City of Albuquerque

RE: Grading and Drainage Plan for NAA, Lot 31, Block 17, Unit 3, Tract 1 (B20-D16)
Dated November 26, 2002

Re: Addition to 8361 Modesto NE, Engineer's Stamp dated 10-19-06
Lot 31 Block 17 Tract 1 Unit 3 of North Albuquerque Acres (B20/D16)

APPROVED GRADING AND DRAINAGE PLAN - 2002

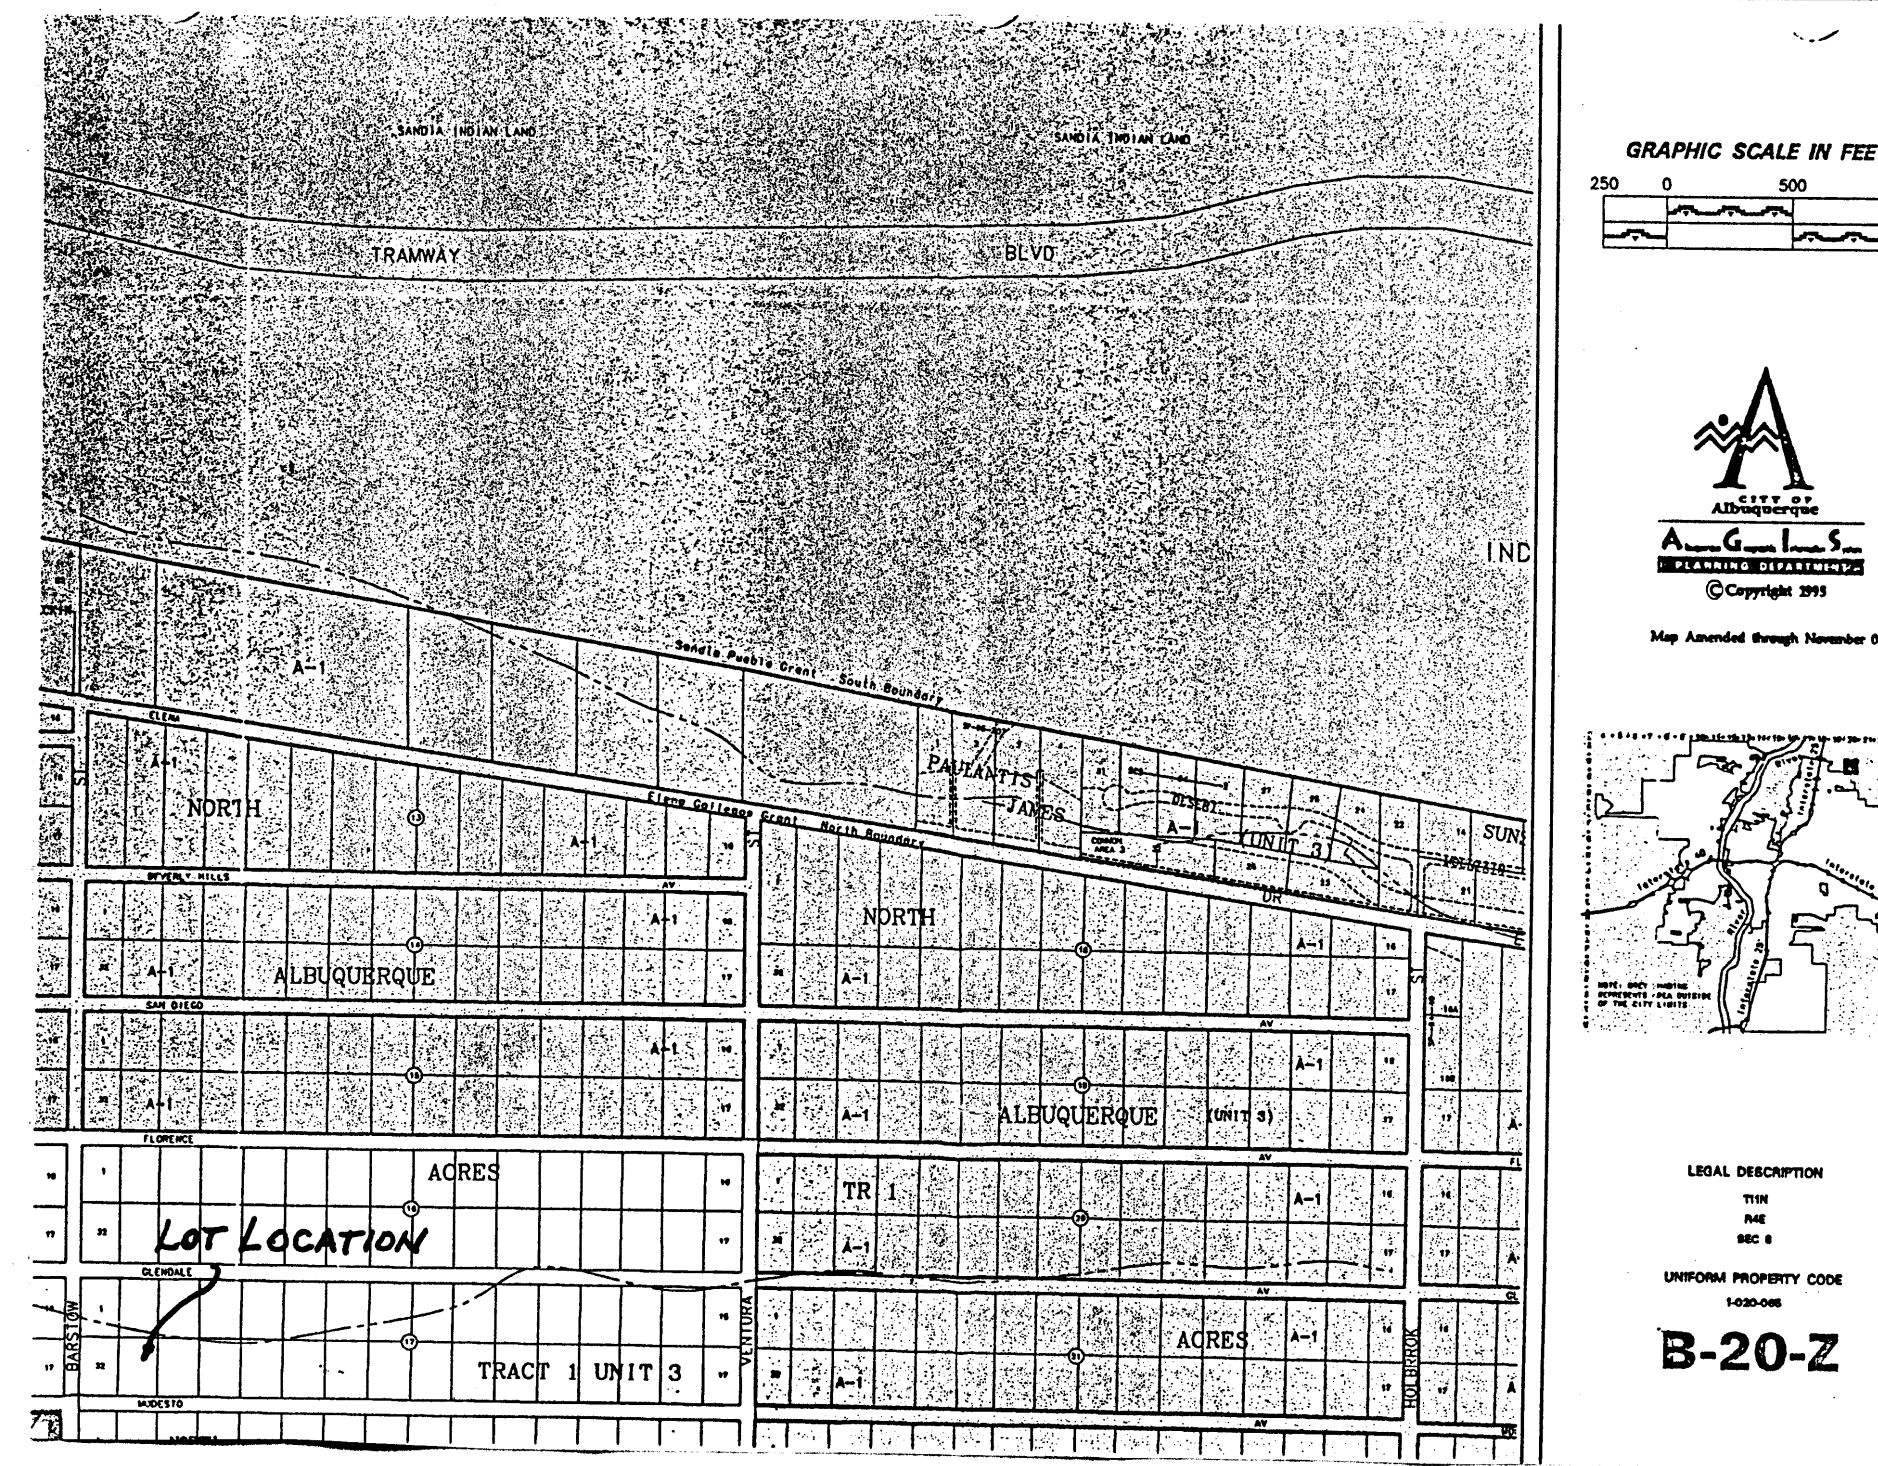
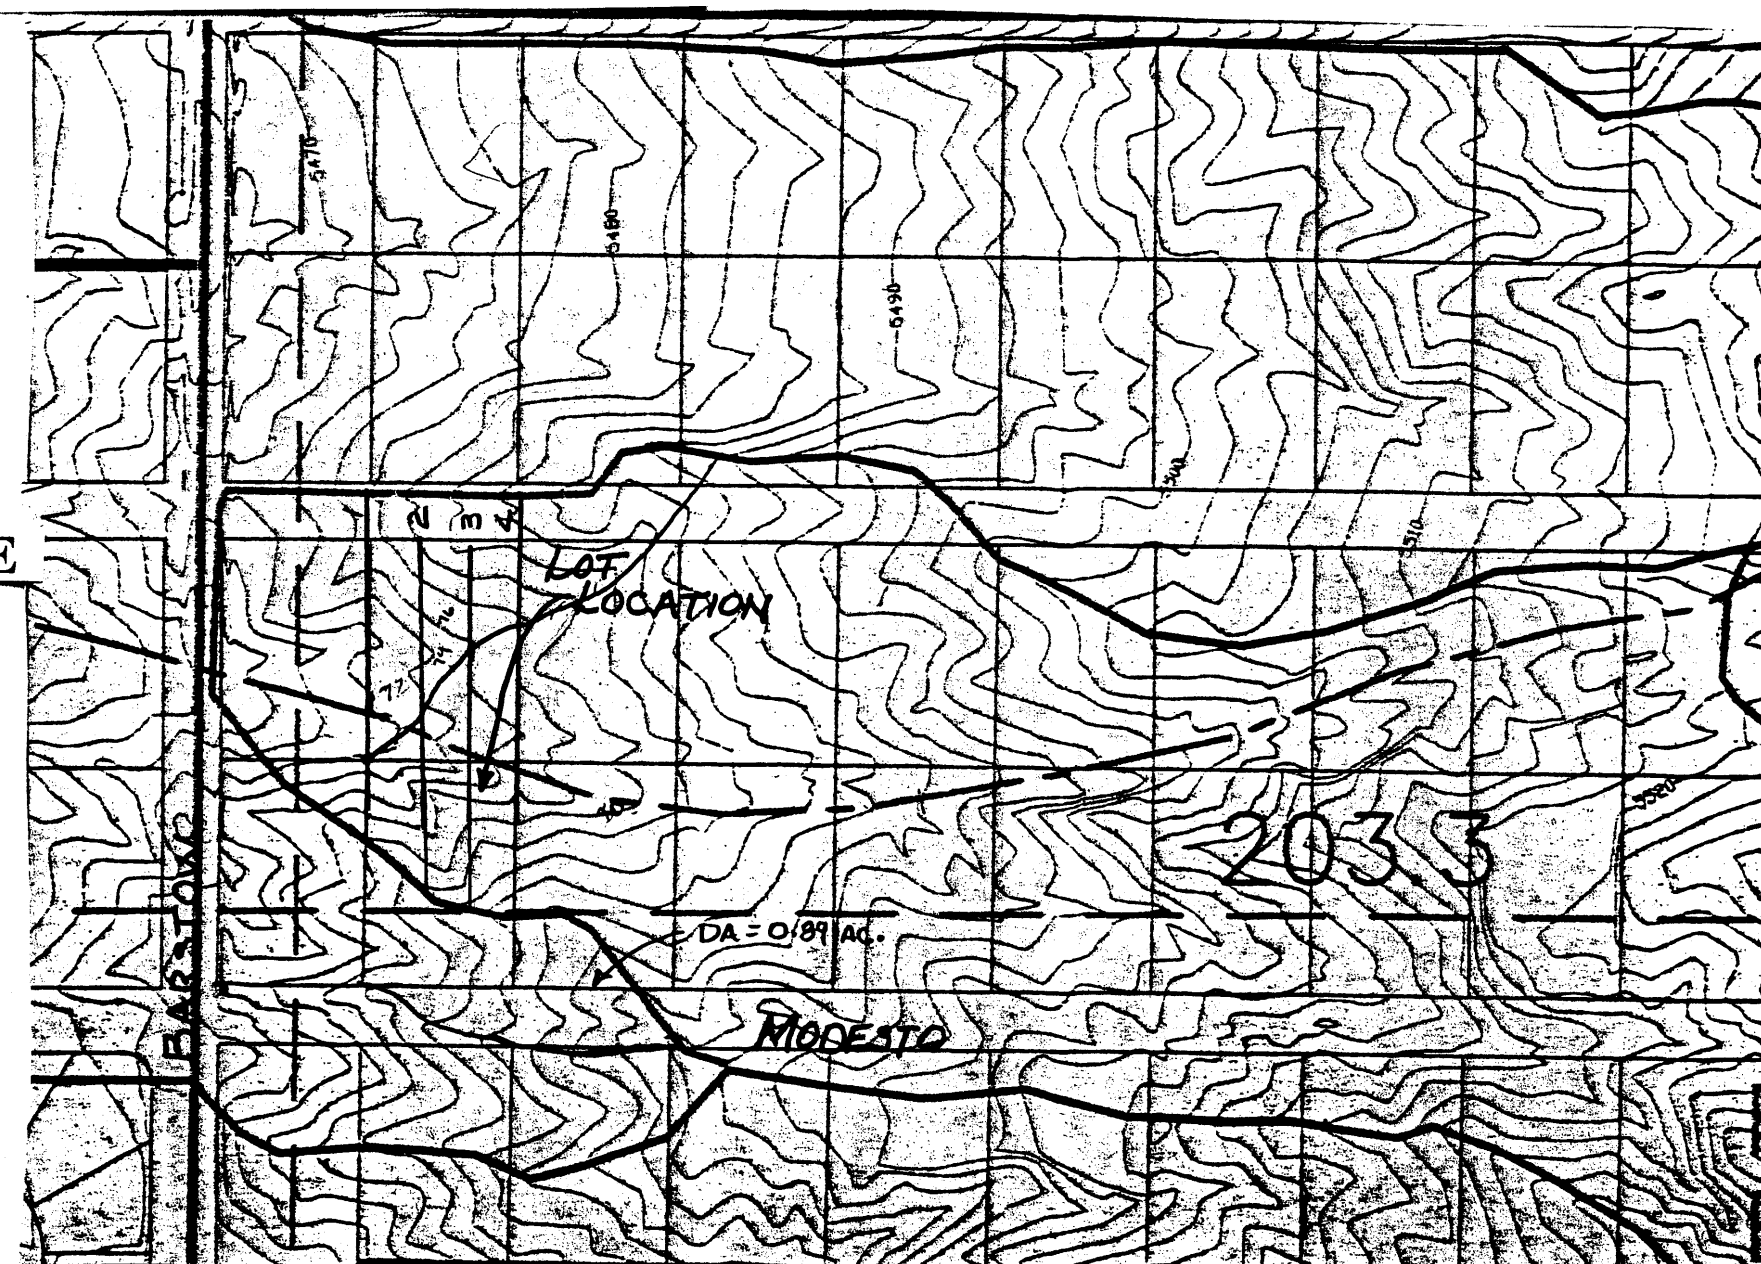
The above referenced plan received March 28, 2001 is approved for Building Permit. Upon completion of the project the engineer will need to certify the project. One item that I would like you to call me on is the small difference for the contours between the off-site drainage map and the grading plan. RTI's floodplain matches yours, but the HEC-RAS and the off-site drainage map elevations are slightly different.
